**Consultation Response from KC,
Trees****2021/94280 land at, Lady Ann Road, Soothill, Batley, WF17 0PY****Erection of 65 dwellings with associated works****Date Responded: 20/01/23****Responding Officer: Nick Goddard****Responding Ref: 72/91**

PROPOSED SITE SECTIONS

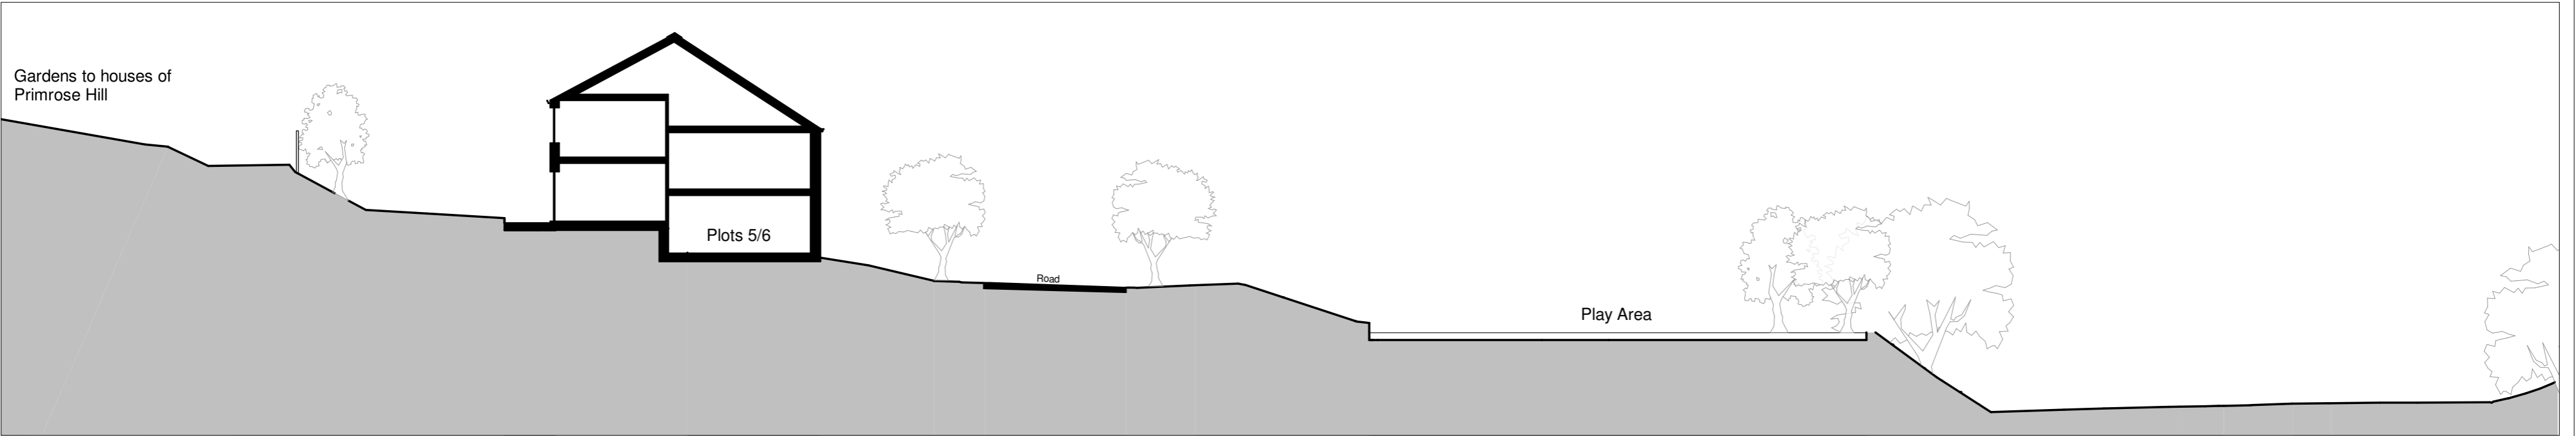
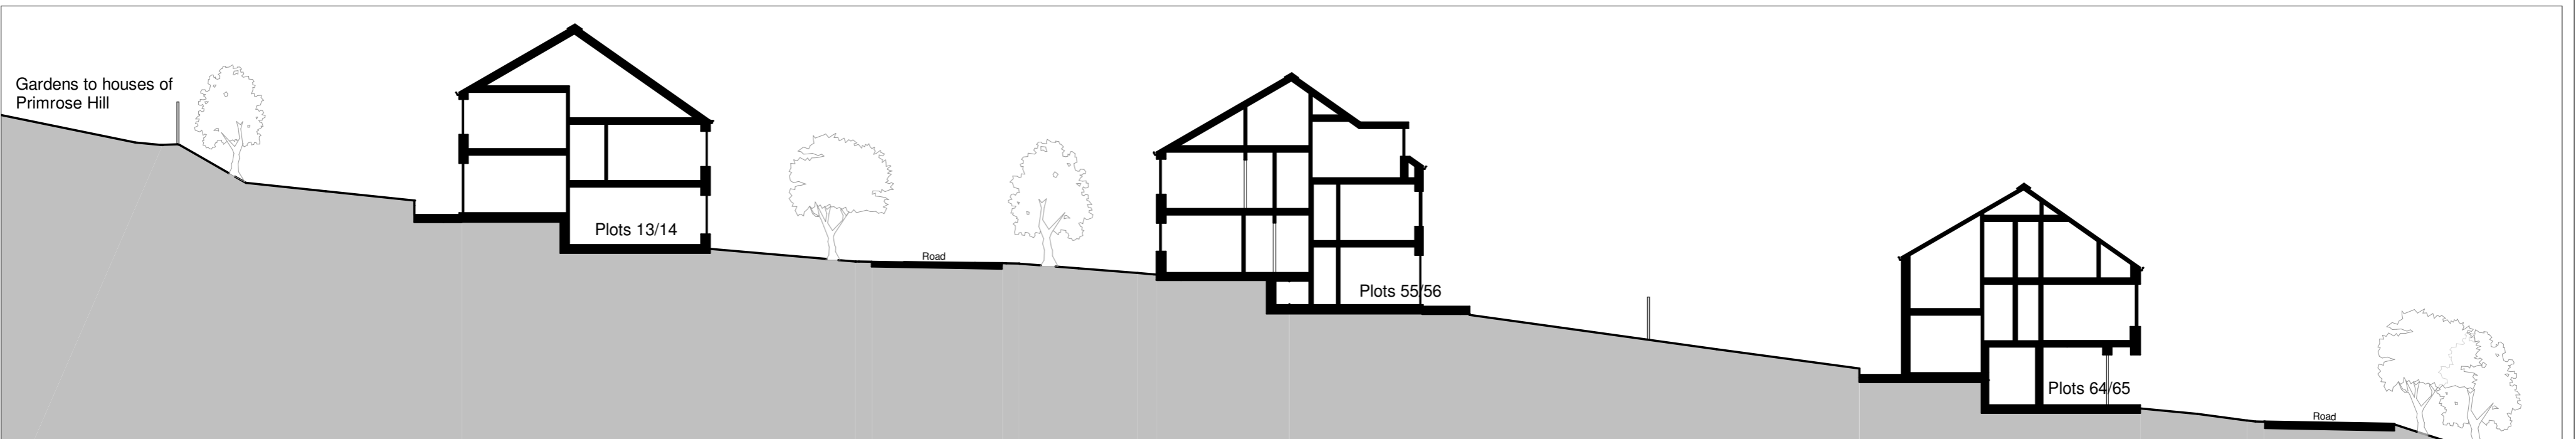
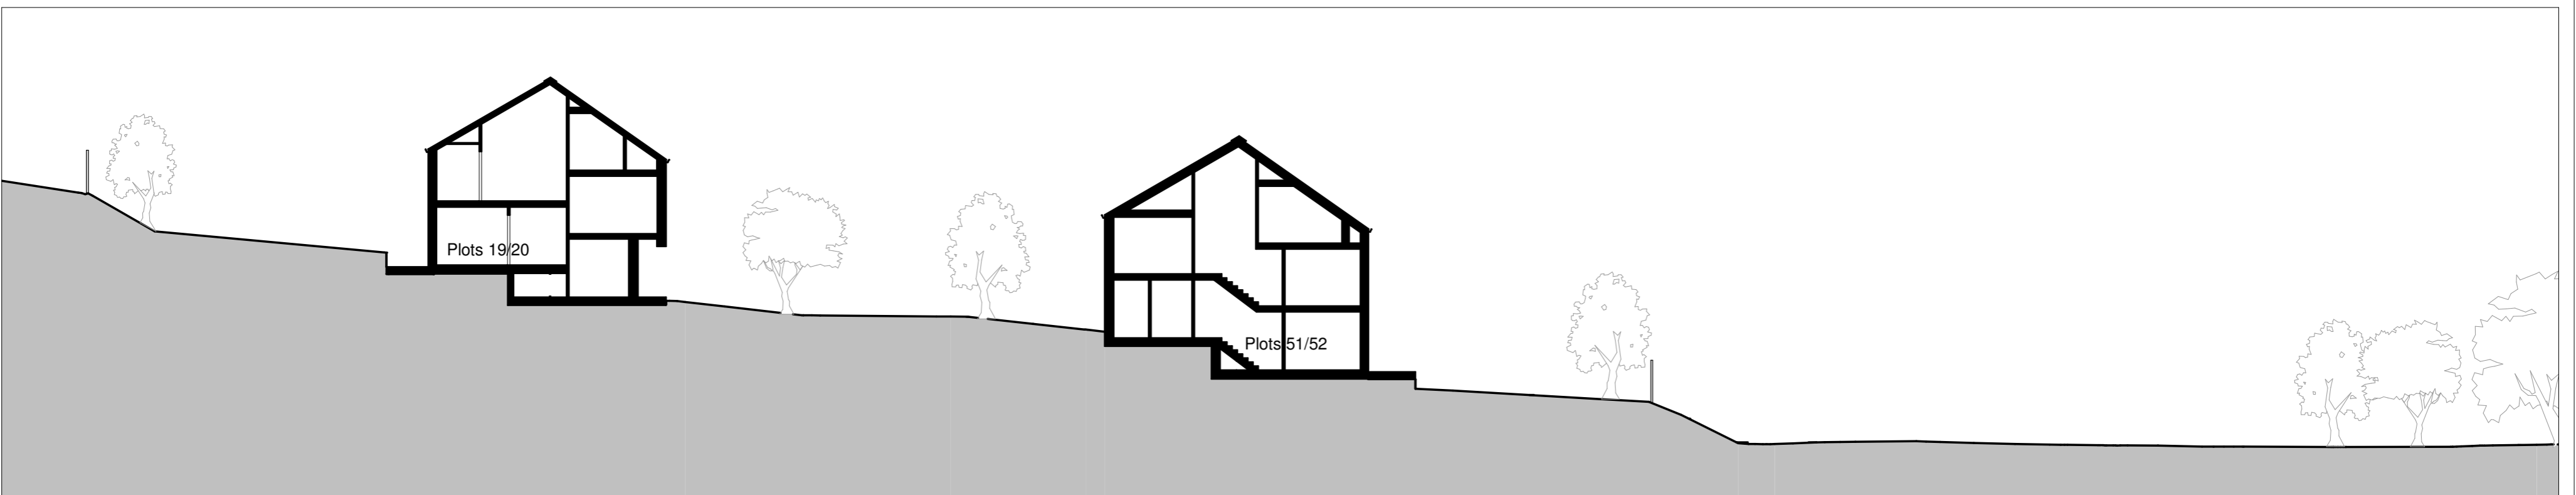
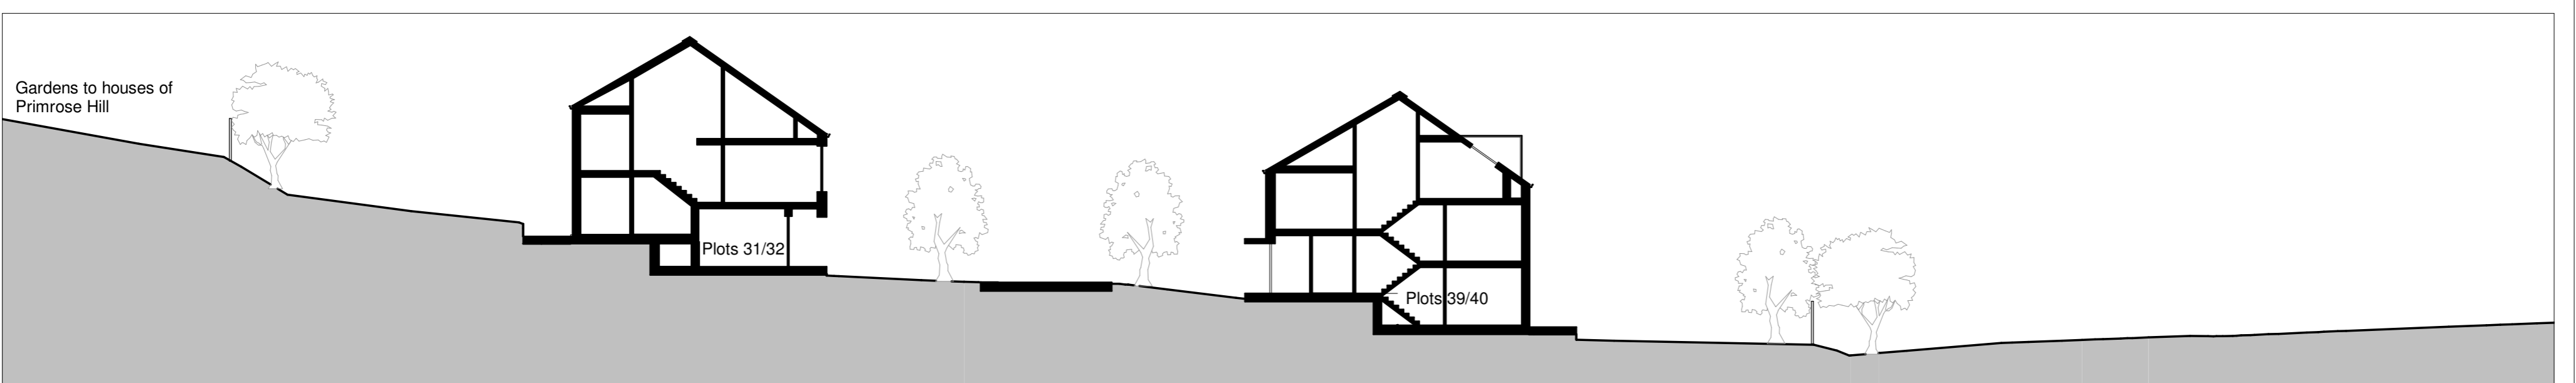
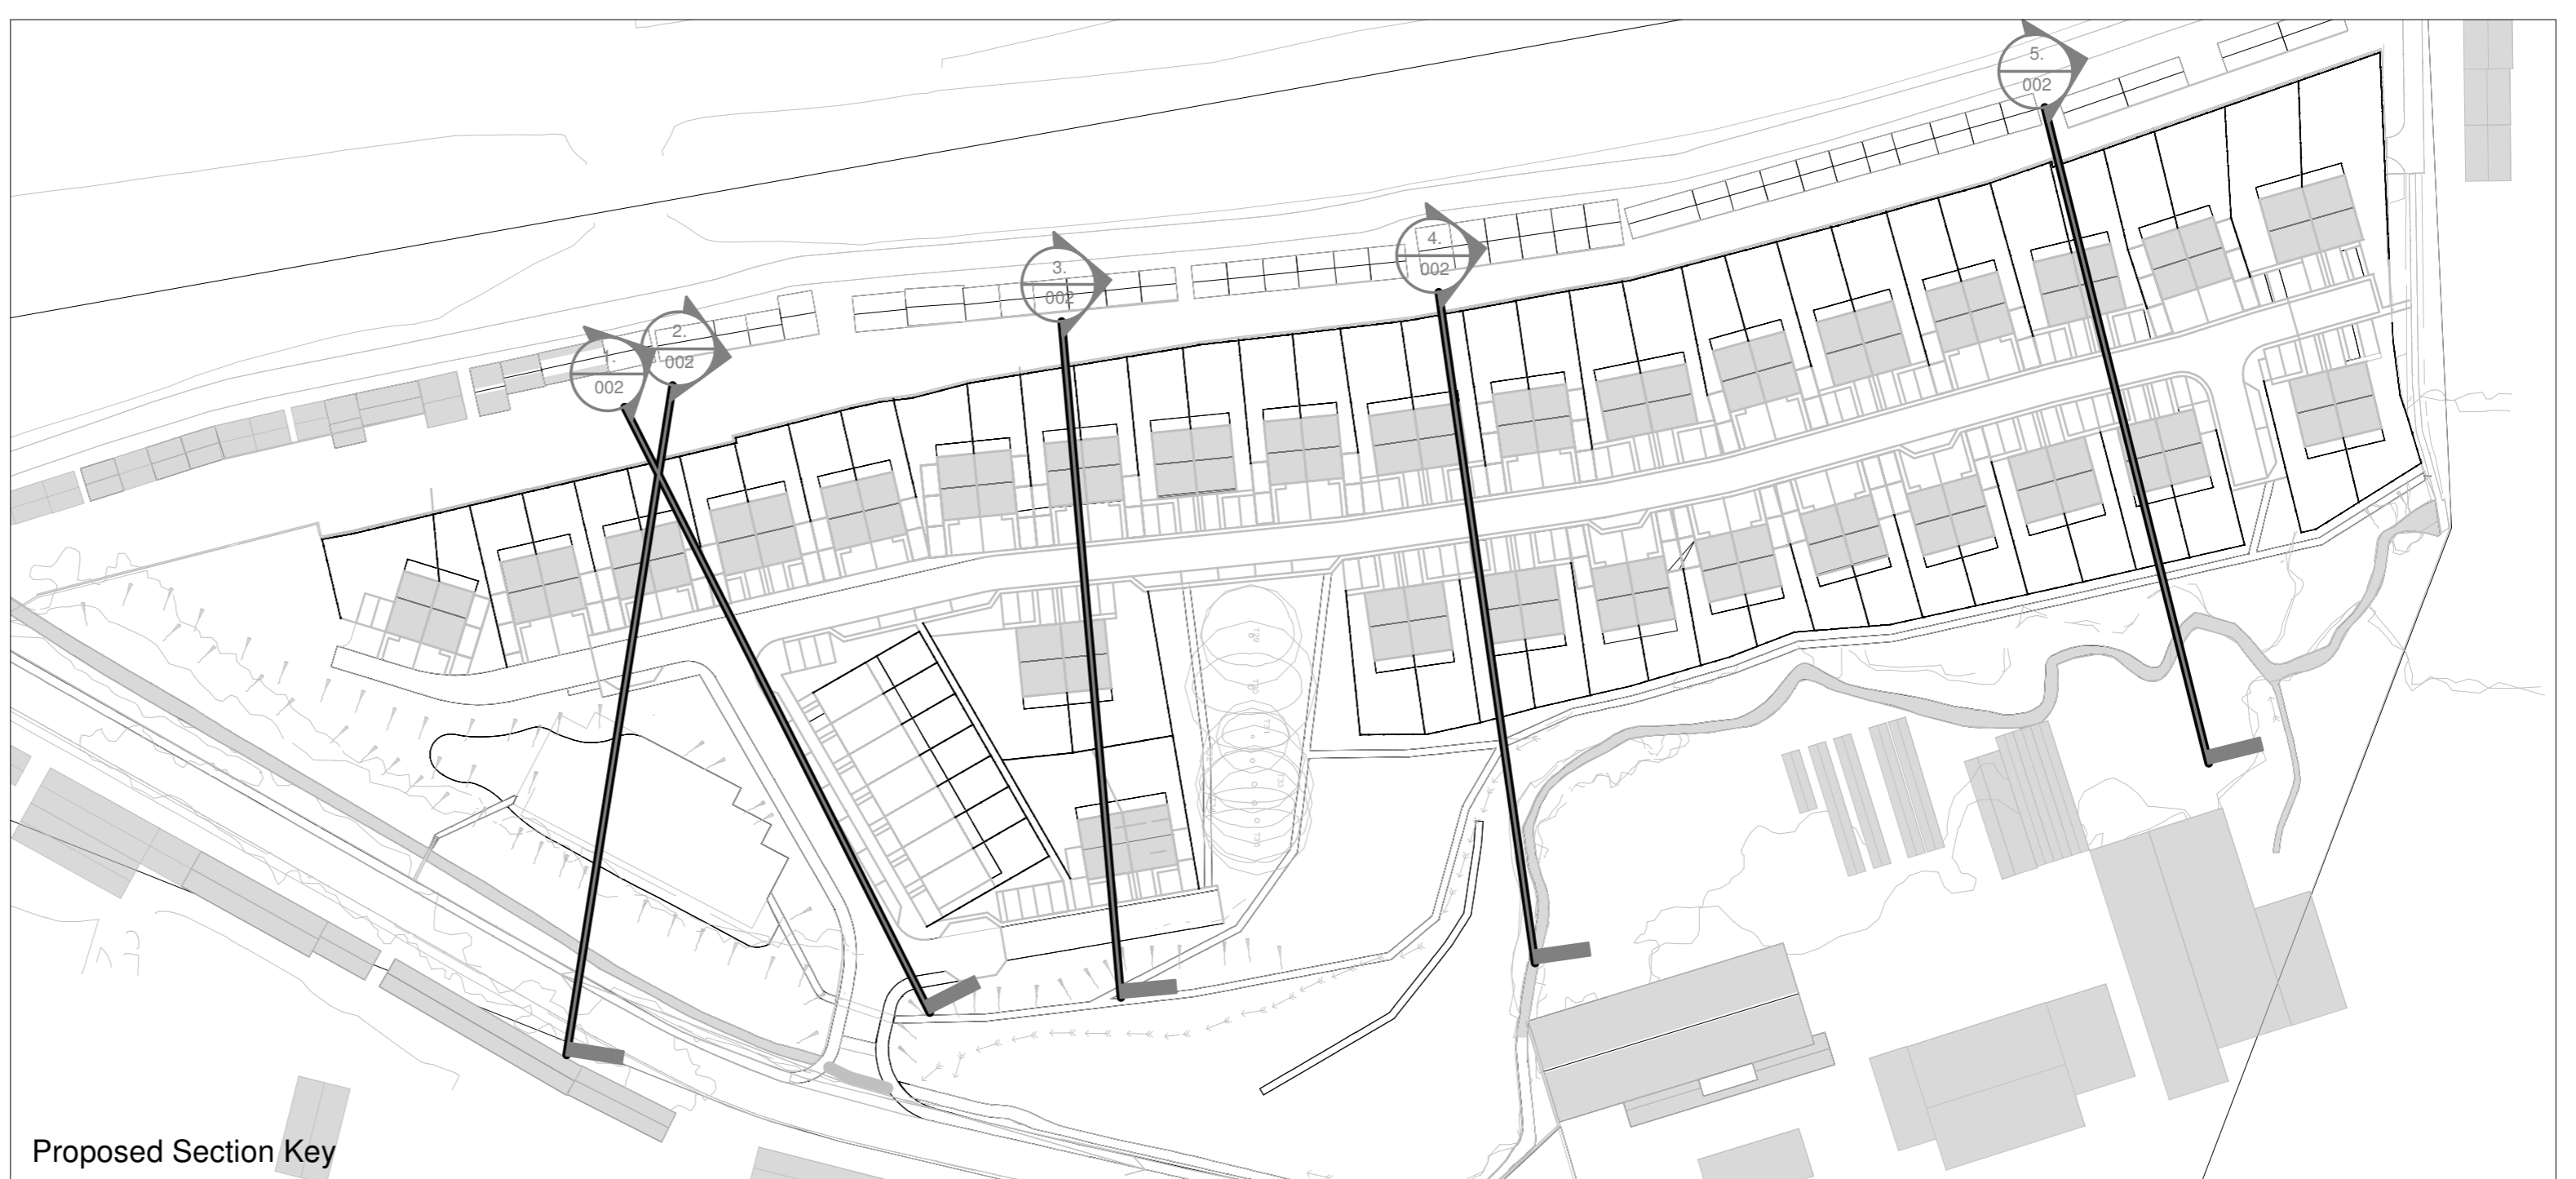
The proposals include the protected trees within the site and the amendments have shown good consideration towards their retention and integration. The finished levels at each side of the ground around the retained trees has avoided the need for large retaining structures or ground level changes will is very welcome.

Footpaths are shown along both sides of the retained trees which will create a good use of the space however these paths will need to be constructed in such a way to avoid excavating roots, details should be provided within an AMS. Details of how trees would be protected from damage during site preparation and construction will also need to be provided in an AMS.

I am happy to support the proposals but would request a detailed Arboricultural Method Statement be provided either prior to determination or prior to commencement in a condition, example below.

Notwithstanding the submitted plans and information, an Arboricultural Method Statement, in accordance with British BS 5837, shall be submitted and approved in writing by the Local Planning Authority before development commences. The method statement shall include a Tree Protection Plan and details on how the construction work will be undertaken with minimal damage to the adjacent protected trees and their roots. Thereafter, the development shall be carried out in complete accordance with the Arboricultural Method Statement.
